Consultation Response from: KC Environmental Health (Pollution & Noise Control)

2025/93210 Land Adj, 178, Deighton Road, Deighton, Huddersfield, HD2 1JJ

Erection of one detached dwelling

Date Responded:
Friday, 23 January 2026

DRAWING TITLE
Location Plan and Existing Site Plan

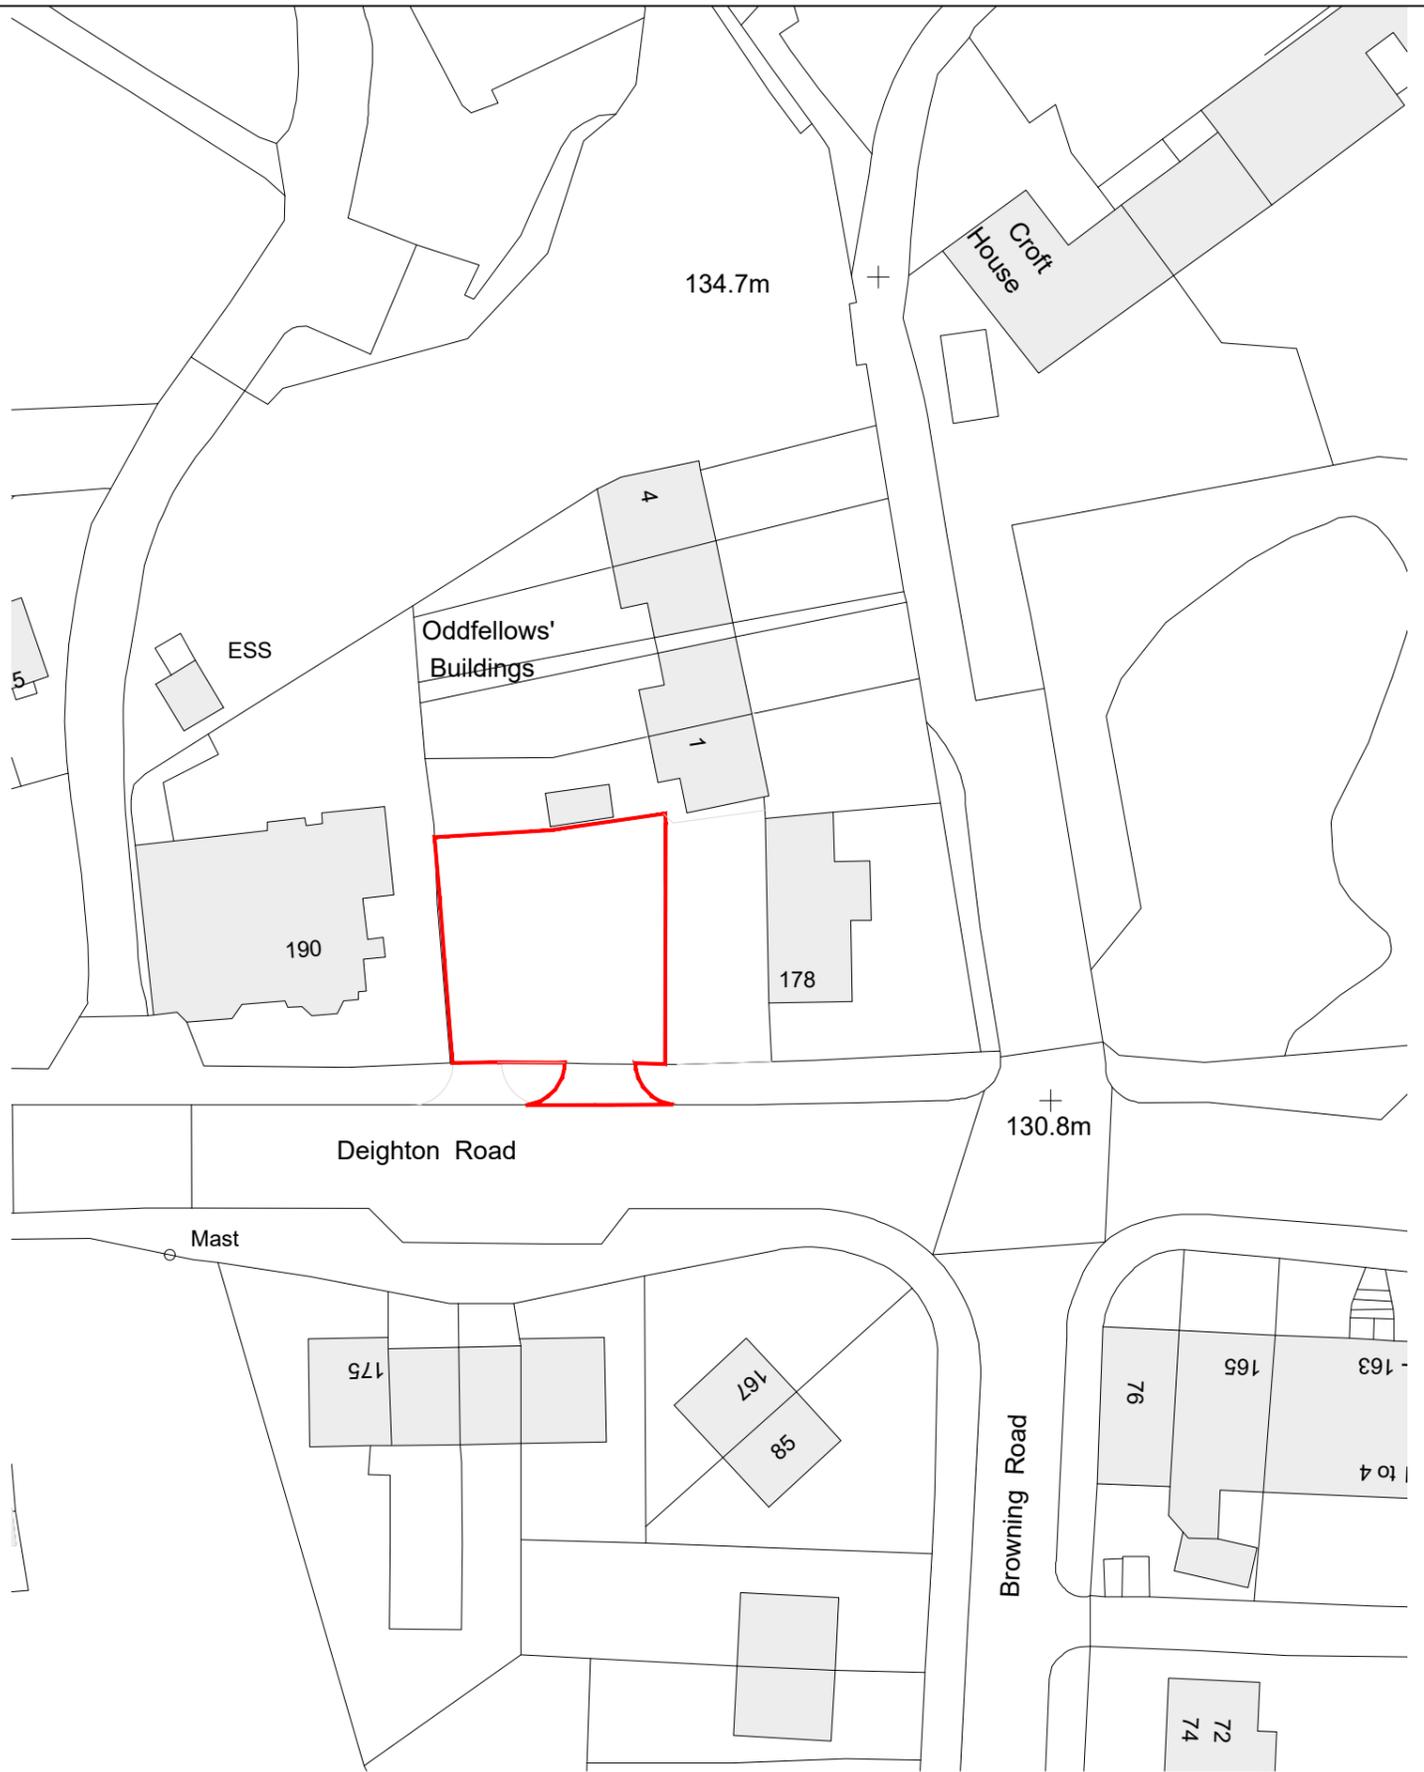
- Further details are required to justify / link back to the sites history, potential sources of contaminants and where sampling was required to confirm whether contaminants associated with past site use are present, or absent.
- The location of sampling should also be linked with the proposed use – it appears that the submitted contaminated land assessments were undertaken for a previous planning application as the submitted plans do not include the workshop within the site

layout. If the site layout has changed, all the contaminated land assessments will require updating with the most recent changes to the site layout.

The additional supporting information provided within the Phase II assessment identifies that the application for erection of one detached dwelling also includes a large workshop. It is not entirely clear if this still applies (as the workshop is not included in the submitted plans).

Further information is required if the workshop is still included to enable Environmental Health to provide an informed and detailed response.

Site 188 DEIGHTON ROAD, HUDDERSFIELD, WEST YORKSHIRE, HD2 1JJ	Date Drawn 19-Oct-22	Date Checked	Orientation 	Job No. NE4118A
Client JAMIE TULLY	Drawn By LMB	Checked By	Scale -	Figure No. 1

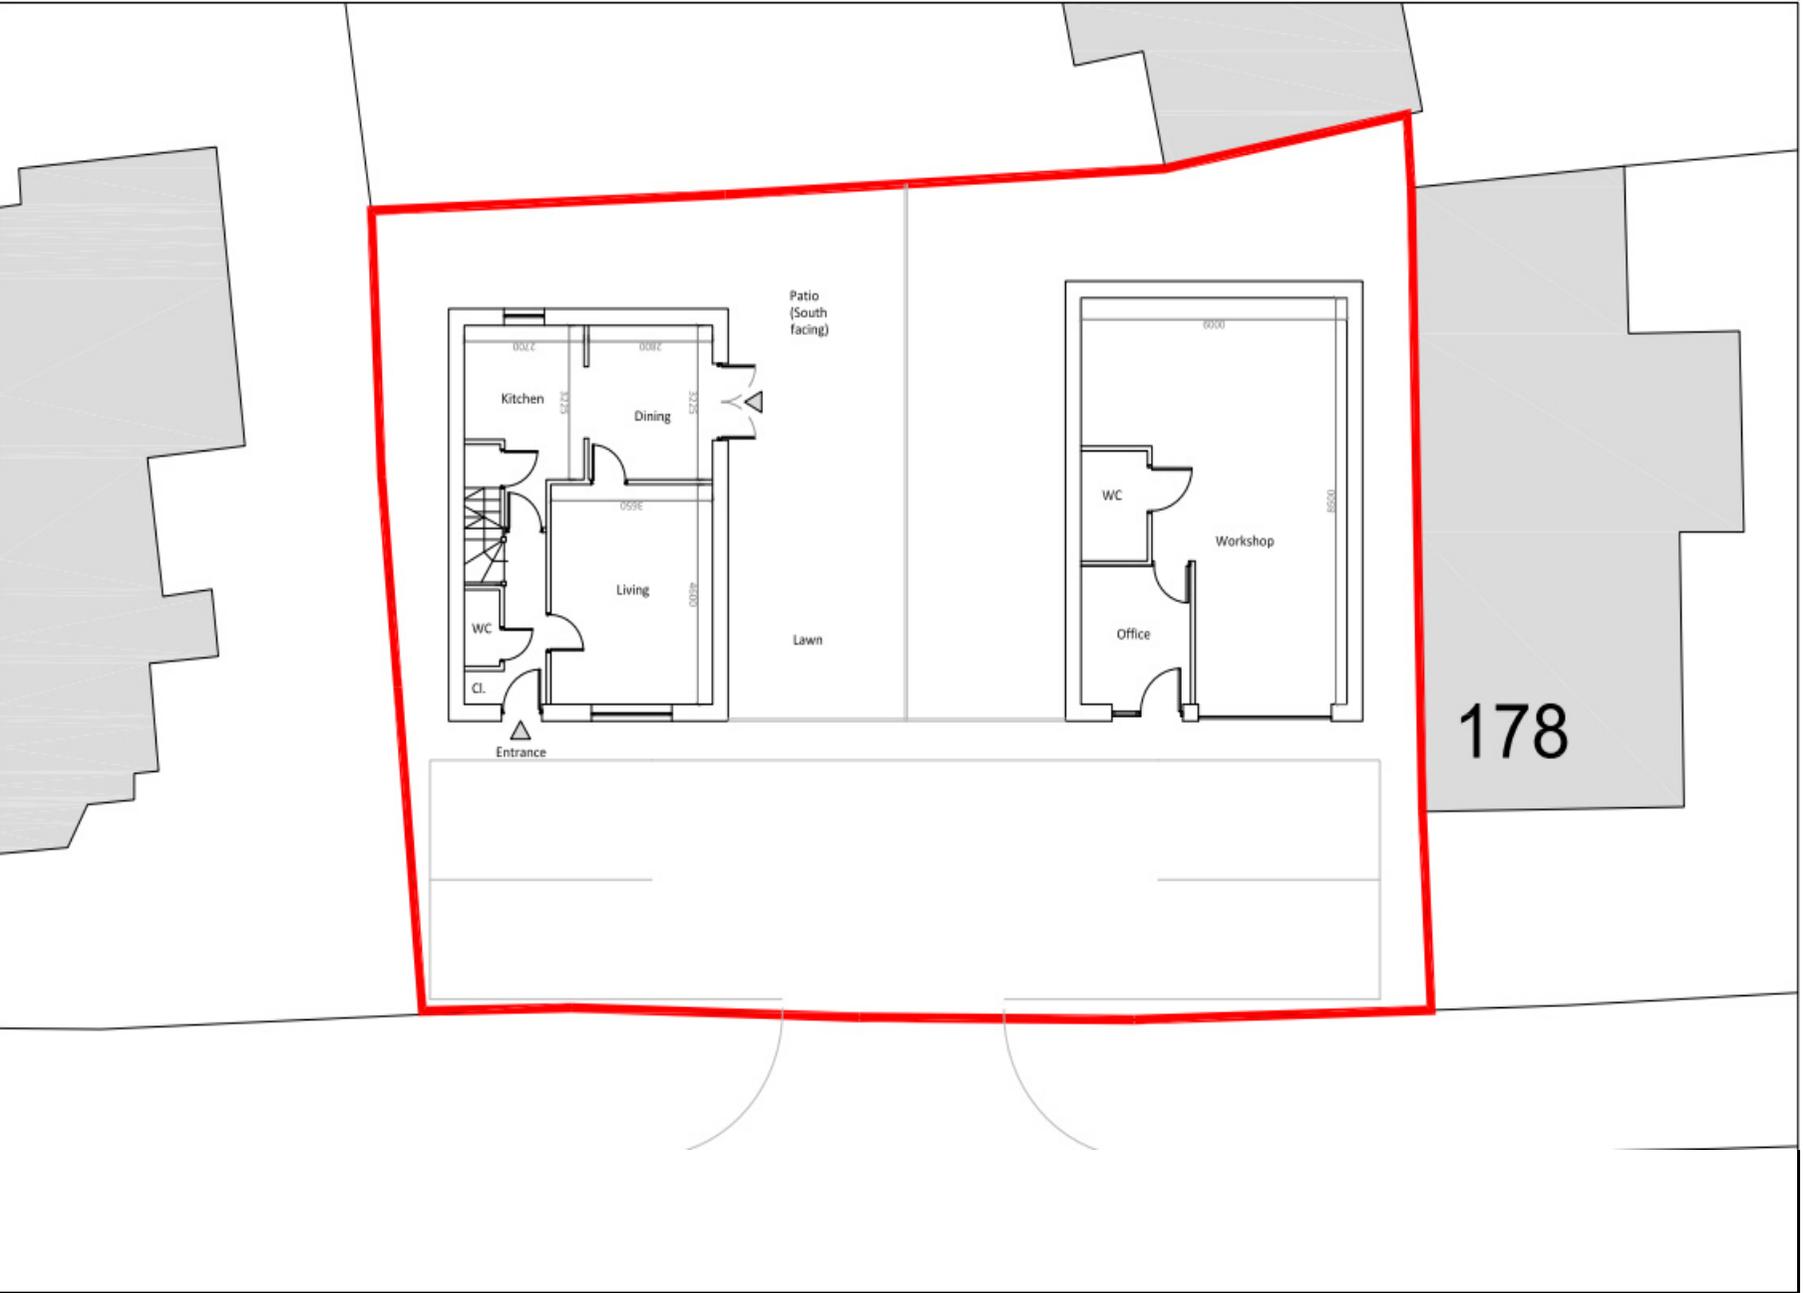
The contamination assessment comprised five soil samples however no details are given to justify the chosen locations/depths of the samples taken. The intrusive investigation should link the soil sampling to previous site usage (justify why sampling was undertaken at particular locations), this was not included in the Phase II report. The intrusive investigation has

It appears that the five soil samples were taken from the hand dug trial pits and some of the mini boreholes, however without further details clarifying why these sample locations were chosen (linked to potential sources of contamination), Environmental Health cannot be satisfied that the investigation was sufficiently comprehensive.
